158 Fore Street - Final Traffic Comments

Hi Nell – The following is a status update of April 8, 2016 preliminary traffic comments and represent my final comments.

SITE PLAN

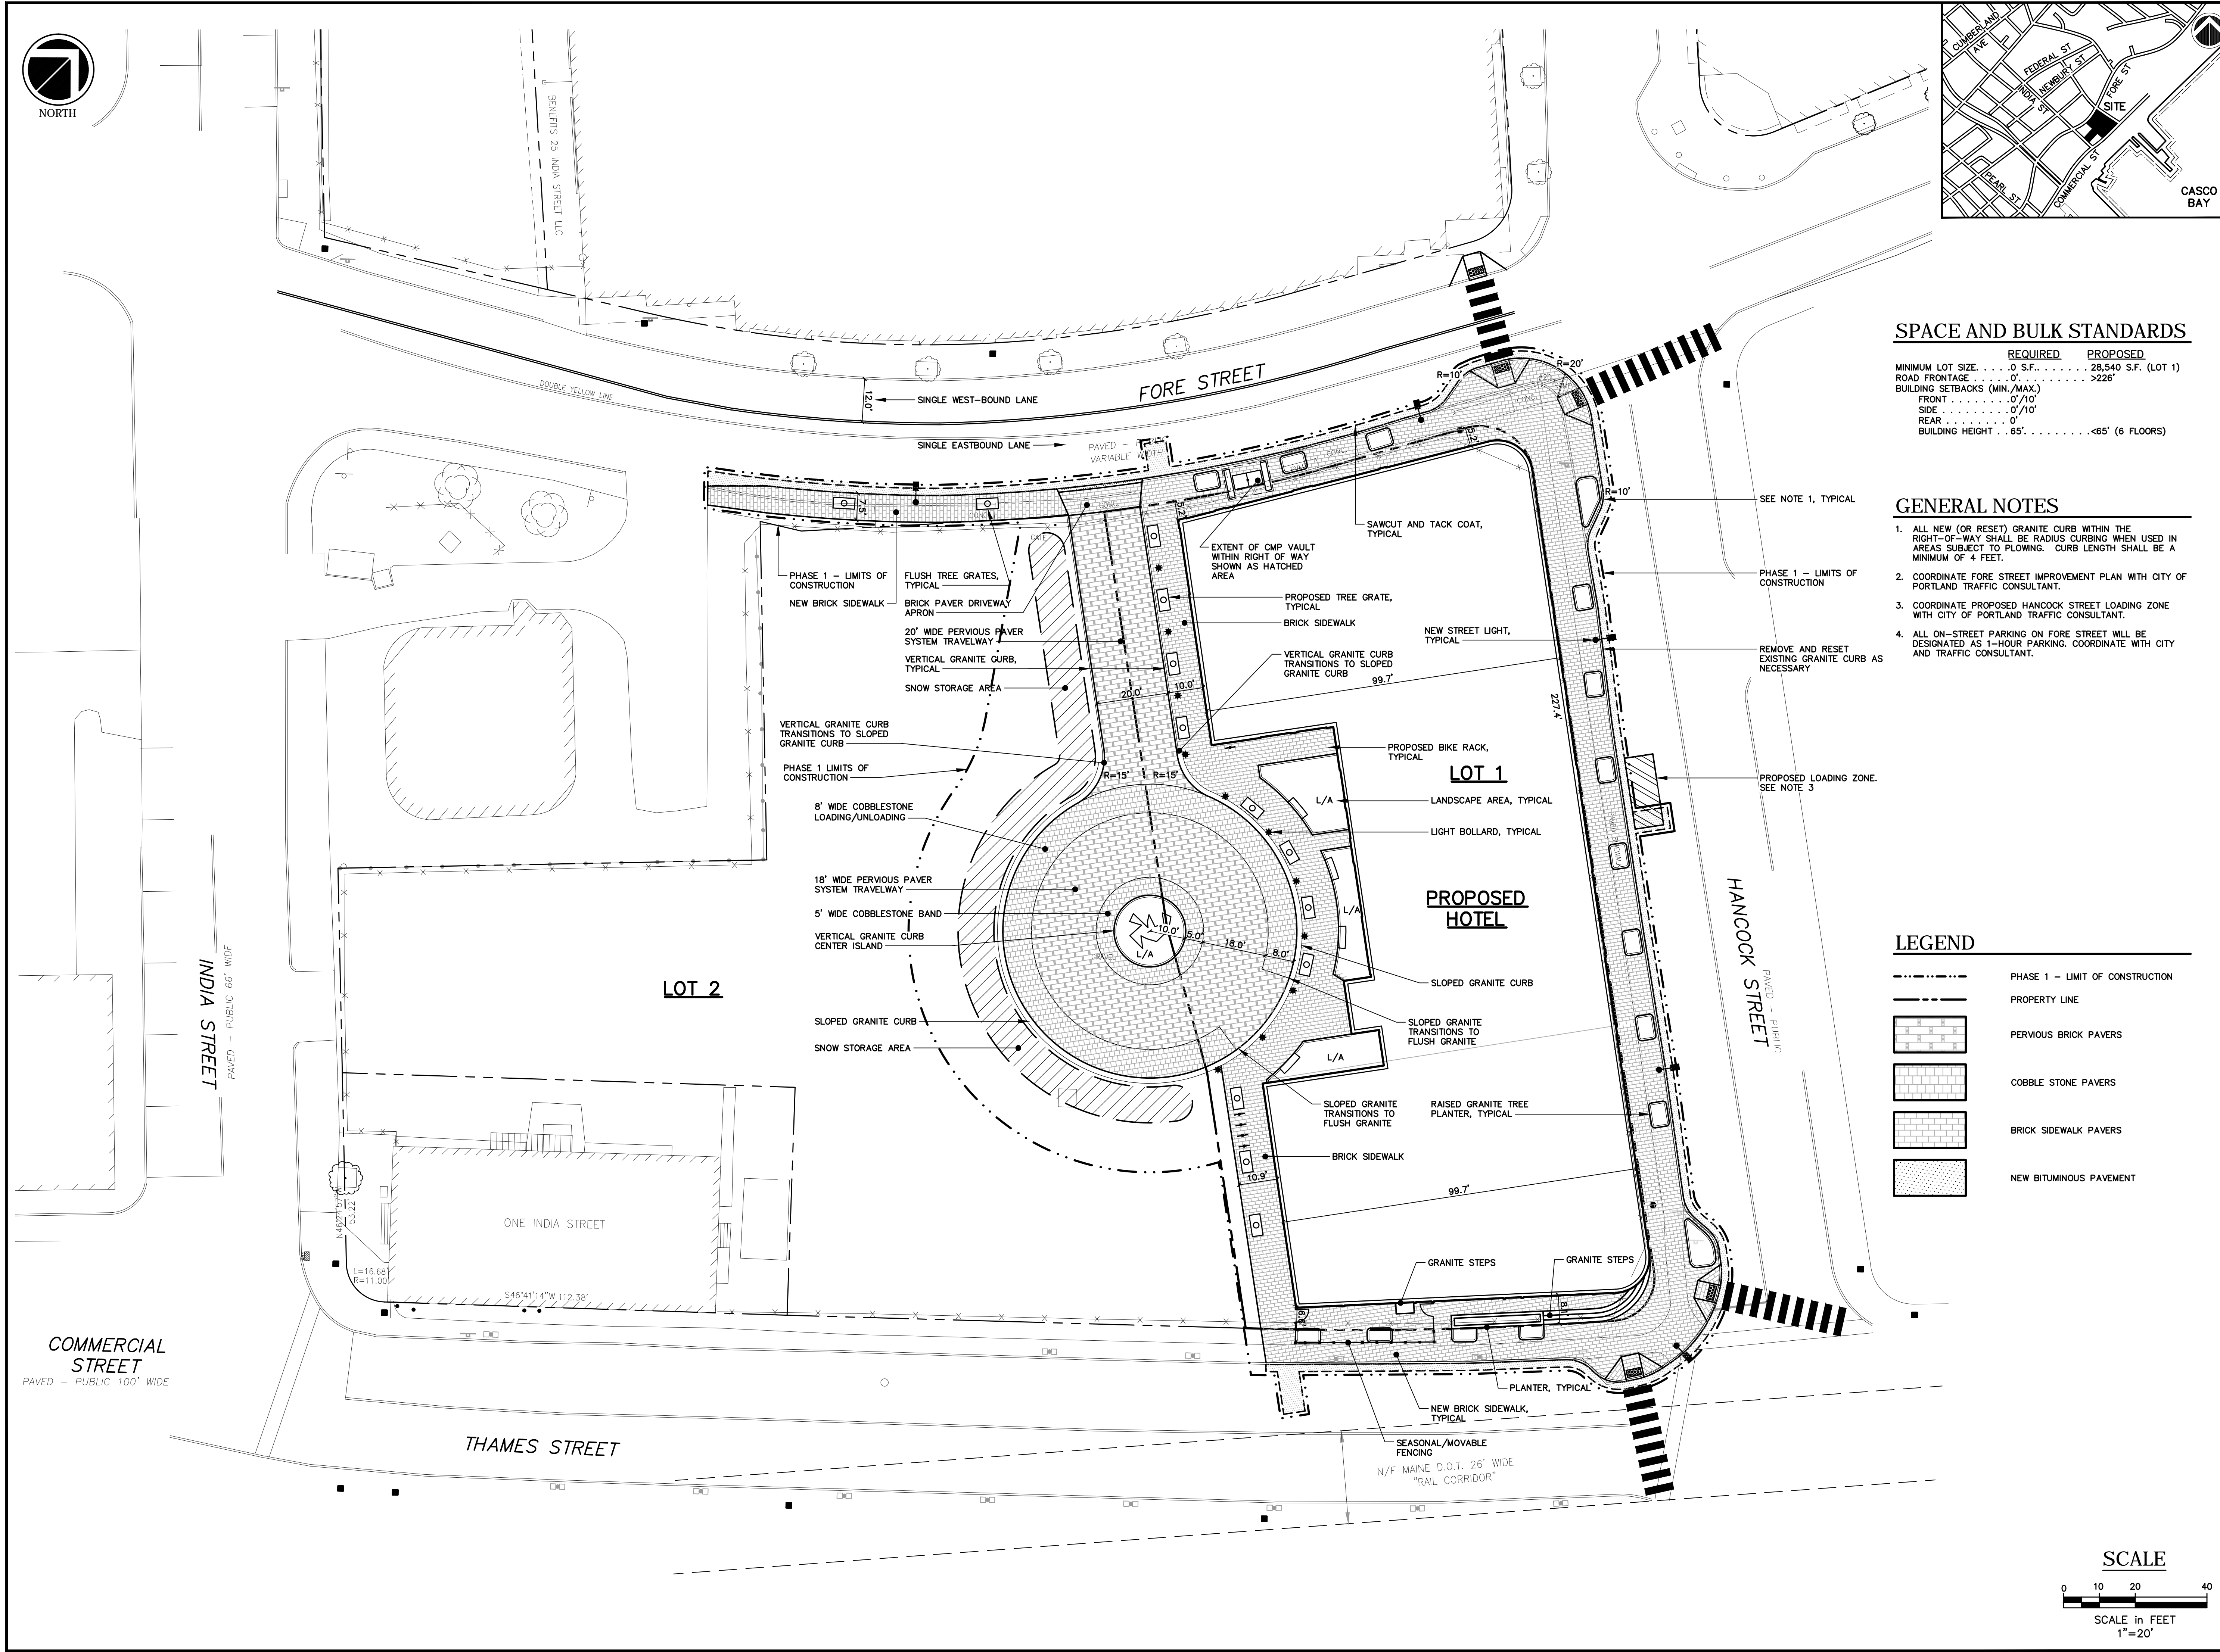
- It is my recommendation that a crosswalk be implemented on the west side of Fore Street at Hancock Street (particularly given use of the Gateway Parking Garage by the project). The crosswalk may include warning signs and shall be fully ADA compliant on both sides of Fore Street.

Status: The current plans do not address this comment. A condition of approval shall be included that requires the applicant to provide final ADA crosswalk, signage, and ramp details for review and approval. The applicant shall be responsible for implementation of the recommended design details. I would note the design shall be the preferred perpendicular crosswalk alignment and include ramps on both sides of Fore Street.

- City staff continues to review the curb extension at the southwest corner of the Fore Street/Hancock Street intersection. Alterations to the ramp configuration and depth of the extension will be required.

Status: Bruce Hyman is coordinating a final layout configuration for implementation by the applicant. I would also note that the applicant will be reconstructing the Hancock Street/Thames Street corner and the current curb

extension as depicted on the site plan will need to be modified from geometric and ramp configuration perspectives. The City will provide direction on the configuration.

- Fore Street is classified as a Collector Street and City standards require 150 feet of corner clearance to Hancock Street. I support a waiver from City standards given that the location of the driveway is approximately midblock between Hancock Street and India Street.

Status: The applicant has maximized corner clearance and the separation standard is almost met (120 feet of corner clearance will be provided). As noted above I support a waiver from City standards.

Filename: ... \000\Highway\002_Striping.dgn

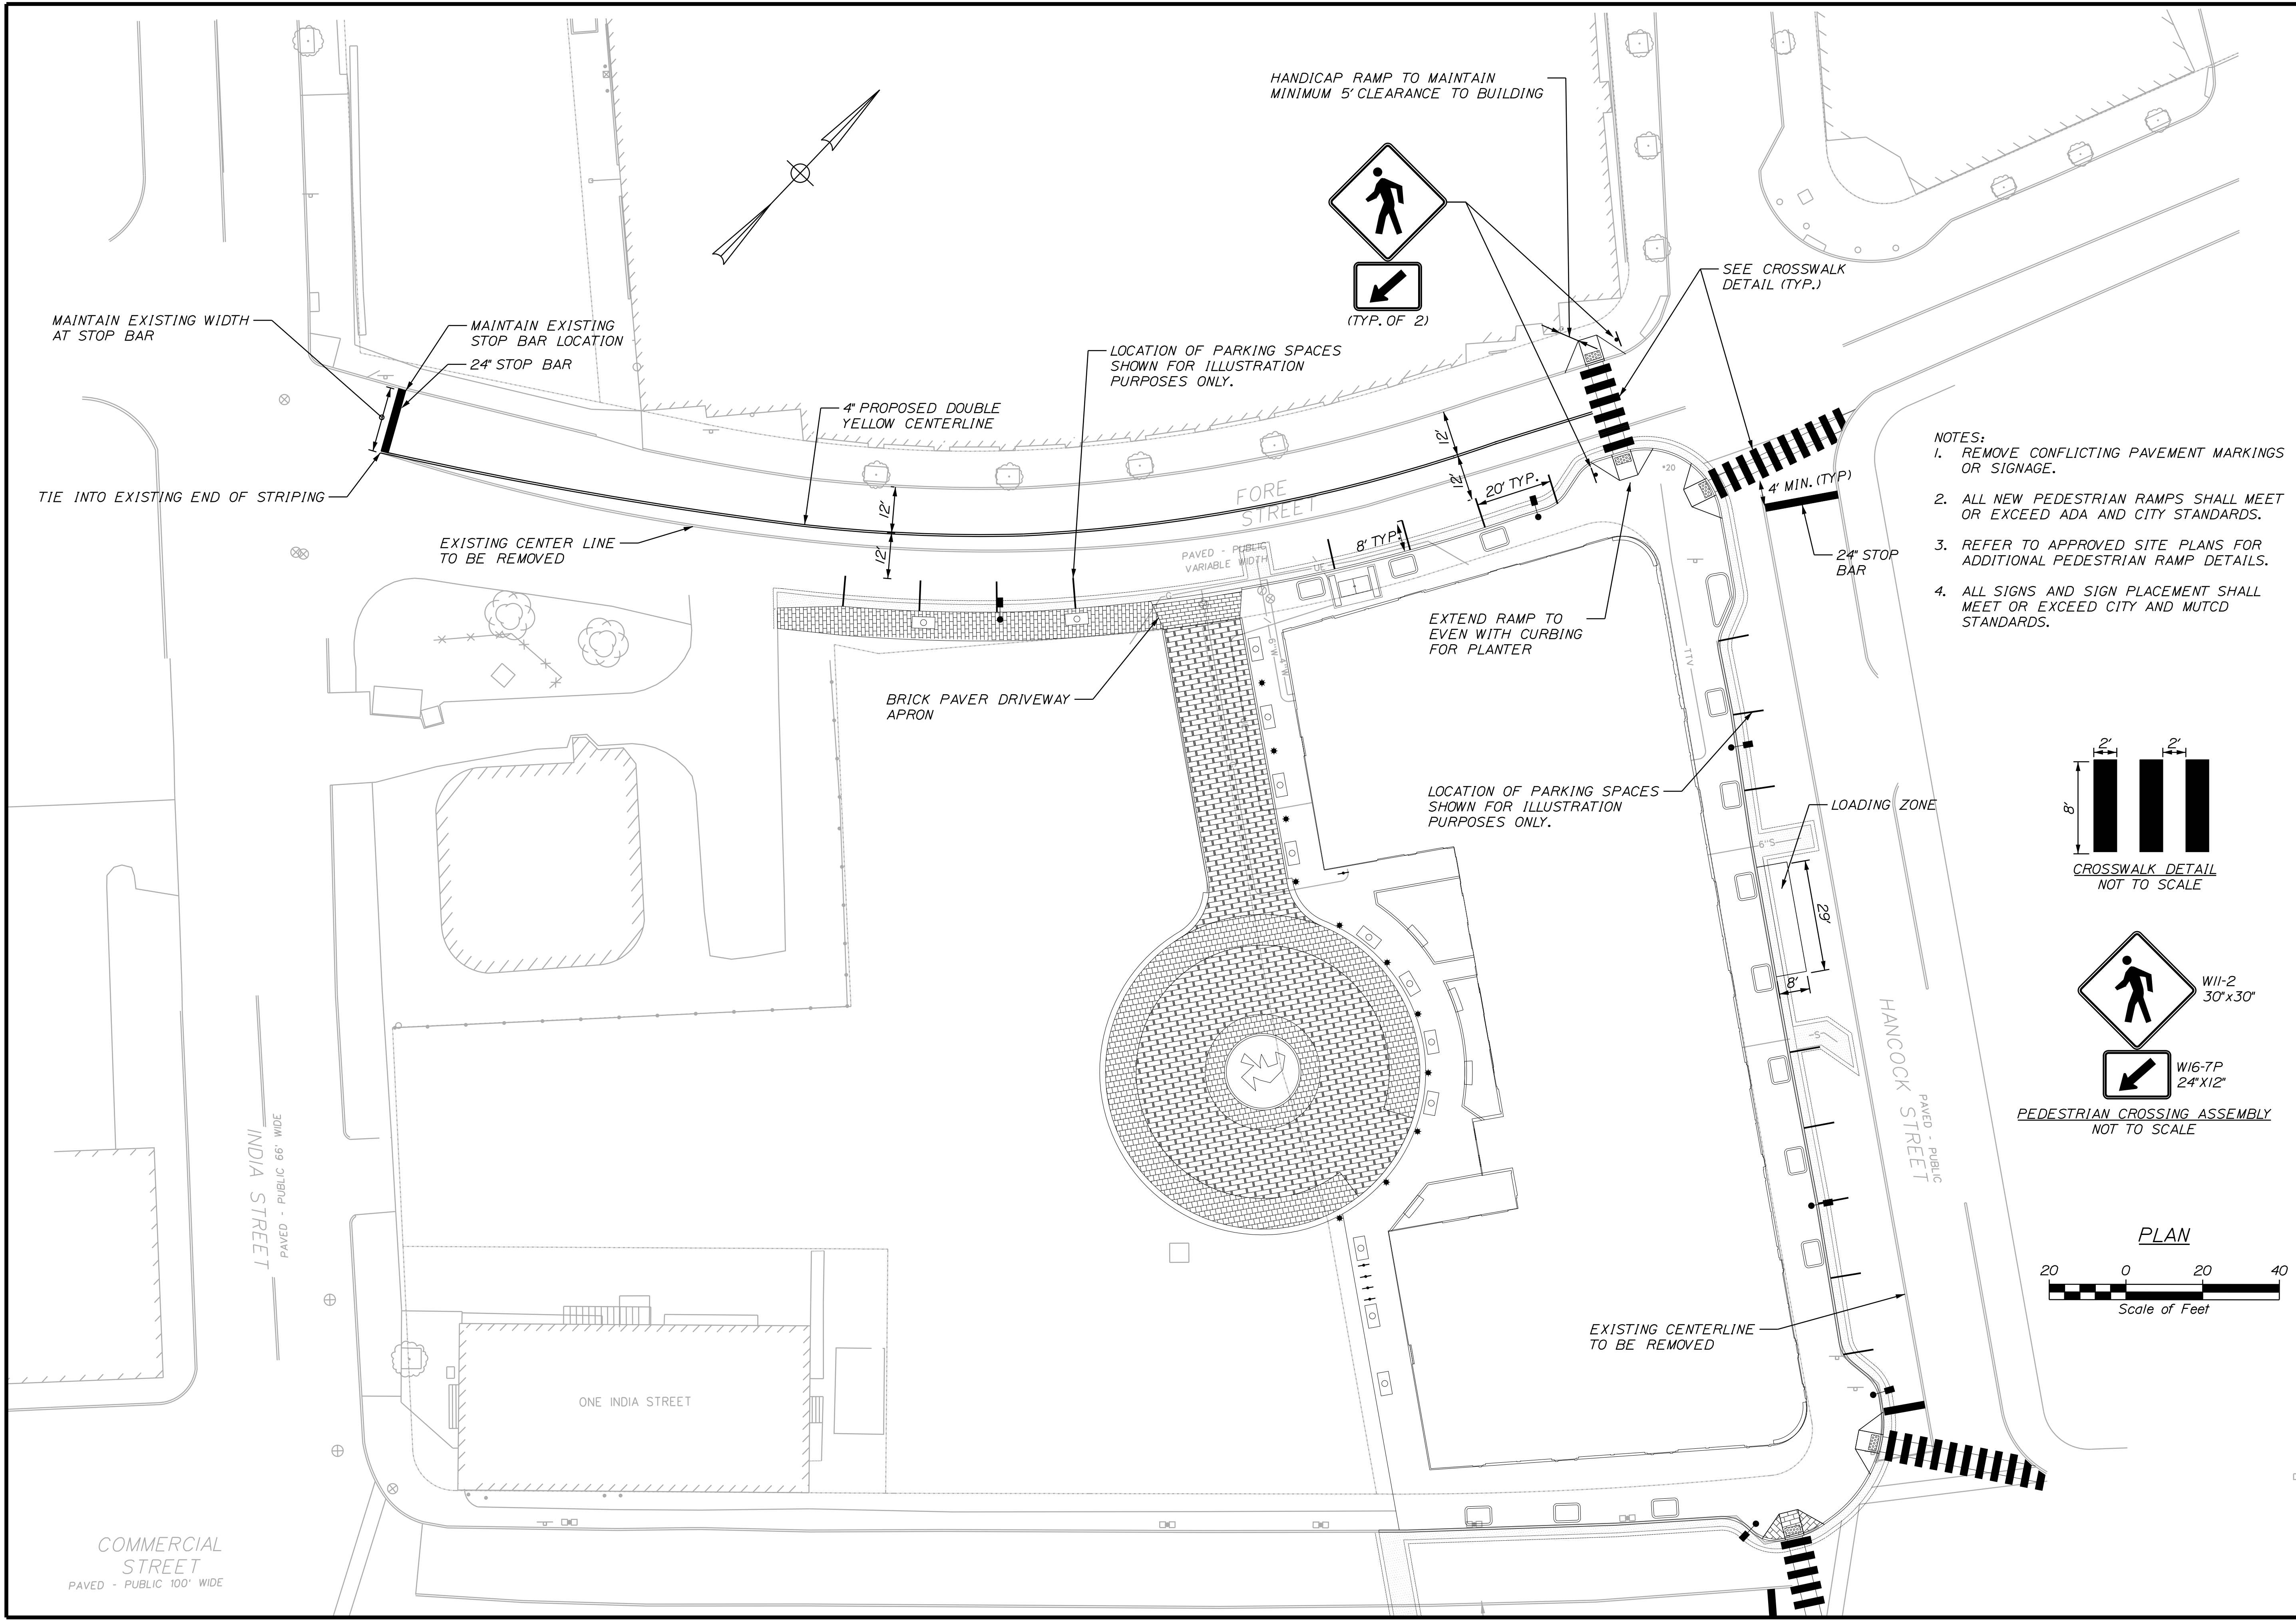
- The applicant will be developing a detailed pavement marking plan for Fore Street that depicts adjustment to the center line and implementation of on-street parking on the south side. I'll review the details upon receipt of the plan.

Status: A condition of approval shall be included that notes the applicant is required to prepare, for review and approval to the satisfaction of DPW, a pavement marking plan. The applicant shall be responsible for implementation of the plan. All details and specifications for implementation shall be approved by the City including but not limited to paint specifications and existing paint removal methods.
